# CITY OF ALBUQUERQUE

**Re: Holiday Park Multigenerational Center, 11710 Comanche Rd NE,**  
**Request for Permanent C.O. –Accepted**  
**Engineer's Stamp dated: 12-05-11, (G22/D008)**  
**Certification dated: 01-11-13**

# CITY OF ALBUQUERQUE

**Re: Holiday Park Multigenerational Center Engineer's Stamp dated 10-21-11  
(G22/D008)**

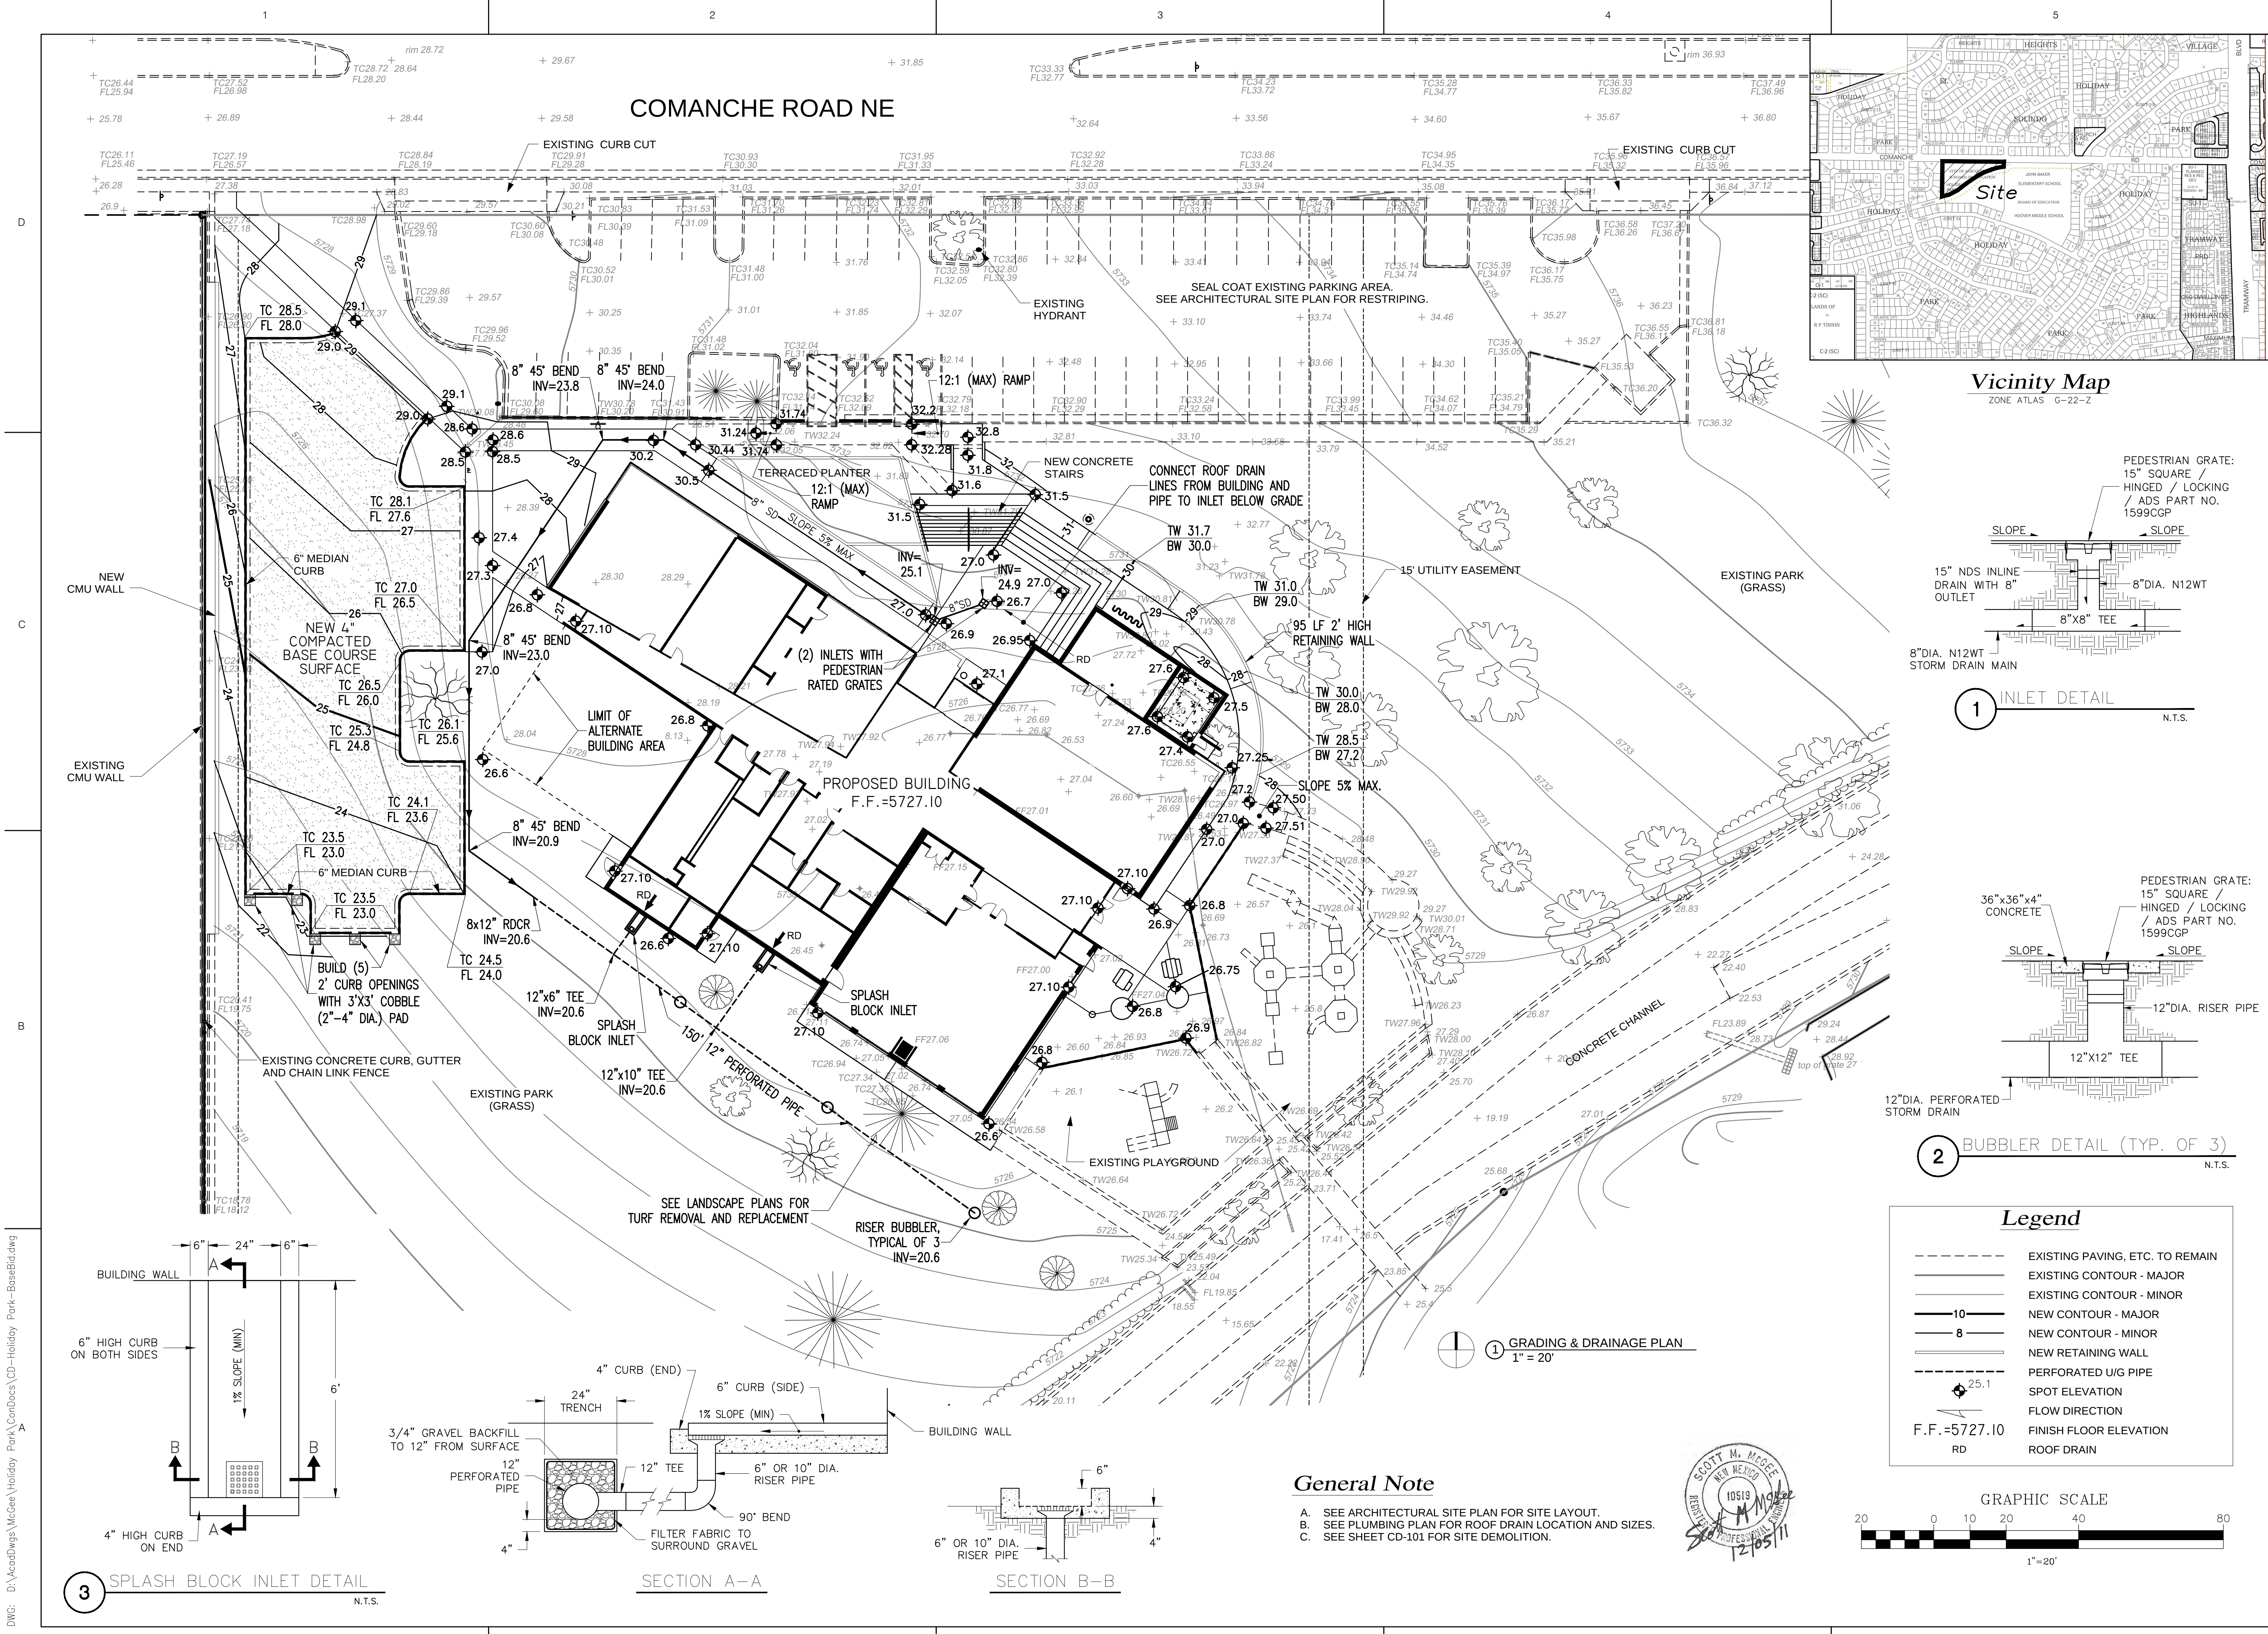
Based upon the information provided in your submittal received 11-07-11, the above referenced plan cannot be approved for Building Permit until the following comments are addressed:

- Provide the amount runoff that drains to the north and to the south.
- How does the southerly portion of the site drain to the existing channel? If through an existing structure please provide location as well flow capacity calculations.
- Label existing contours.
- Show the limits of the existing drainage easement along the existing channel.
- Enlarge the vicinity map, and include a FIRM map.

Hydrology is requesting that proposed landscape areas be depressed to retain/infiltrate the rain that falls on them. If you have any questions, you can contact me at 924-3695.
